Rezoning Petition
for
Charter Properties
Charlotte, North Carolina

For
Public Hearing
Rezoning Petition
2001-145

CHARLOTTE-MECKLENBURG
PLANNING COMMISSION
INTER-OFFICE COMMUNICATION

SUBJECT: Administrative Approval for Petition No. 2001-145, Charter Properties, Inc.

Technical Data Sheet
For
Public Hearing Rezoning Petition 2001-145

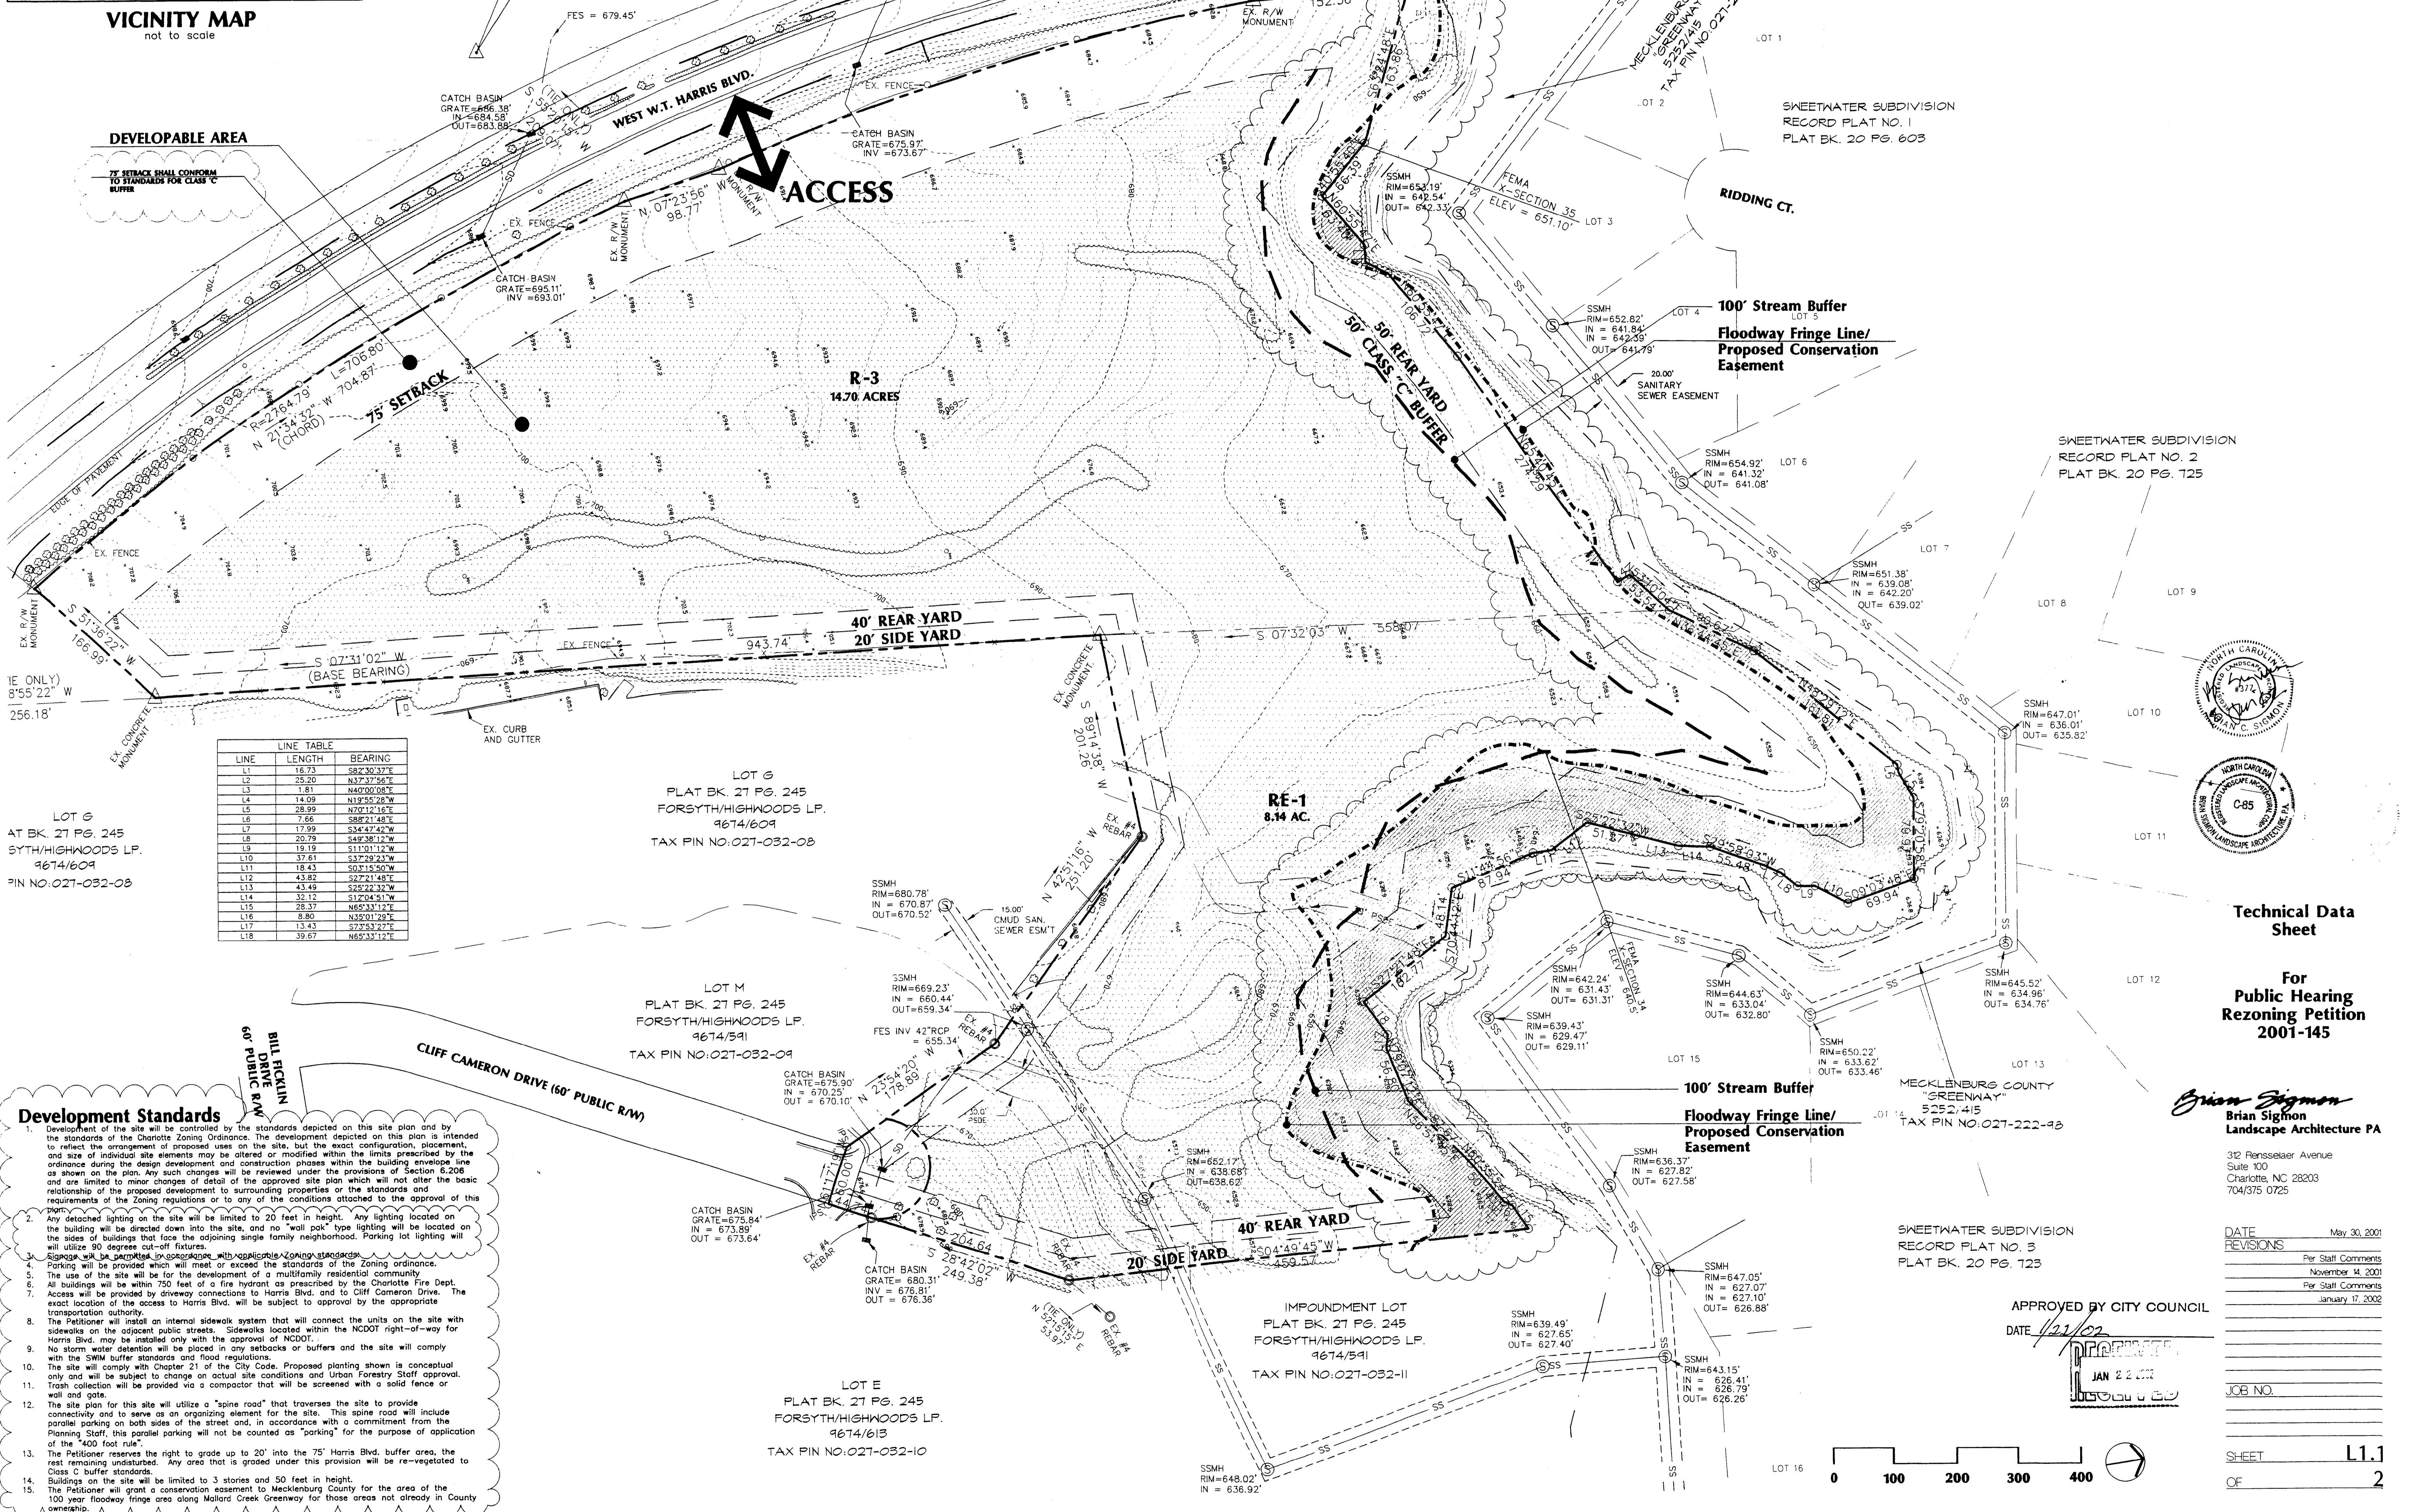
Attached is a revised site plan for the above rezoning petition. The plan has been revised to substitute the shrubs in the 75-foot buffer along West W. T. Harris Boulevard with one small maturing tree for every five required shrubs. Since this change is minor and does not alter the intent of the conditional plan, I am administratively approving this revised plan. Please use this revised plan when evaluating requests for building permits and certificates of occupancy.

- At the developers option, shrubs required in the 50' Class C buffer and as described in statement #13 above may be substituted at a ratio of one (1) small maturing tree (5'-6' H) for every five (5) required shrubs. These trees can be placed between the 50' Class C Buffer and the disturbed area.
